**From:** Katie Crosbie <[KCrosbie@hillingdon.gov.uk](mailto:KCrosbie@hillingdon.gov.uk)>  
**Sent:** Tuesday, September 5, 2023 5:31 PM  
**To:** Danny Morbey <[dannymorbey@hotmail.com](mailto:dannymorbey@hotmail.com)>  
**Cc:** Cara Morbey <[morbeycara@gmail.com](mailto:morbeycara@gmail.com)>; [bill@wjmacleod.co.uk](mailto:bill@wjmacleod.co.uk)  
**Subject:** RE: 23 Pembroke Road, Ruislip, HA4 8NQ - 28220/APP/2023/1292

Proposed Roof Plan

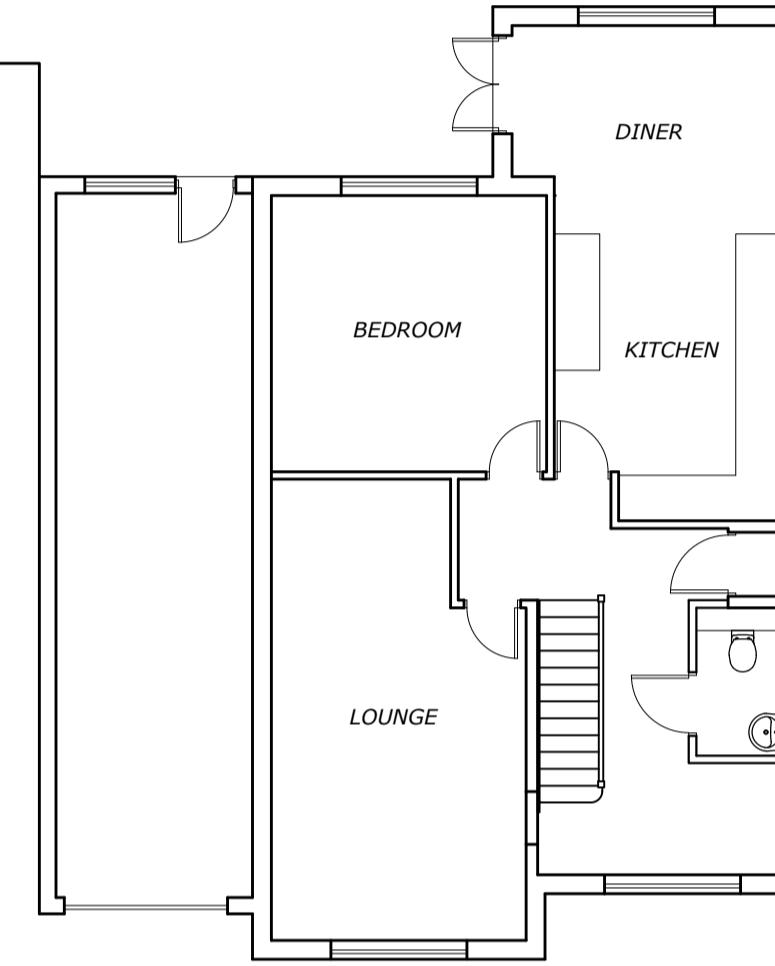
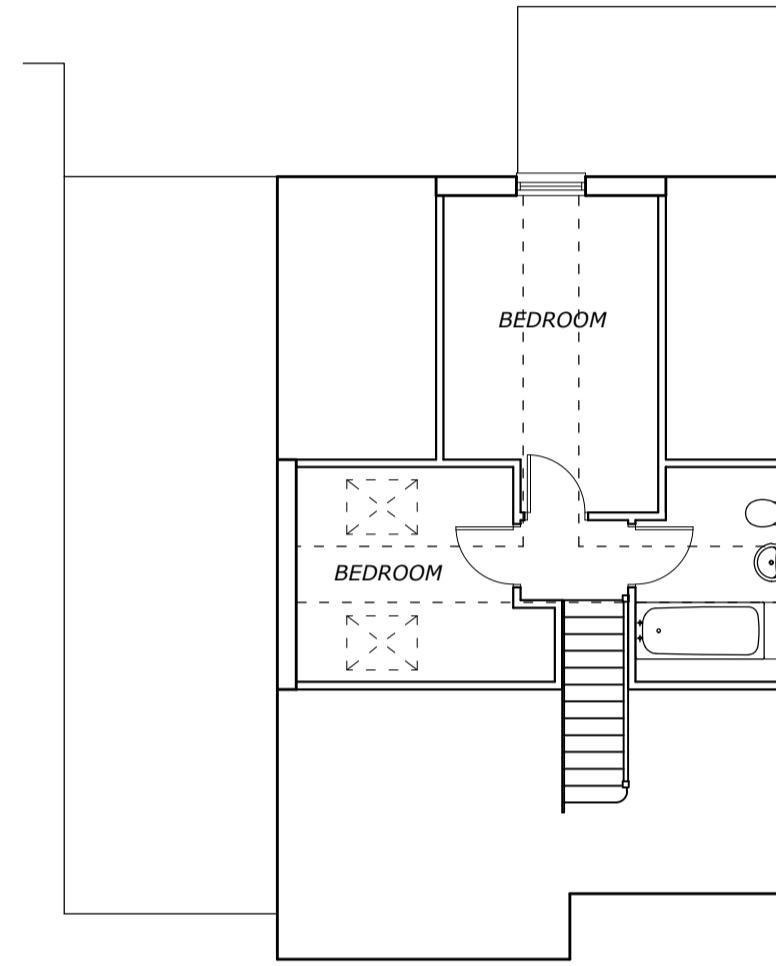
Before submitting I would recommend that you also include an existing roof plan. You should also annotate on the drawing that materials used in any exterior work must be of a similar appearance to those used in the construction of the exterior of the existing dwellinghouse. Also, with respect to the first-floor side elevation window serving the bathroom the design should be altered so that it is high-level opening. The drawing should also be annotated to say that this window would be obscure-glazed and non-opening unless the parts of the window which can be opened are more than 1.7 metres above the floor of the room in which the window is installed.
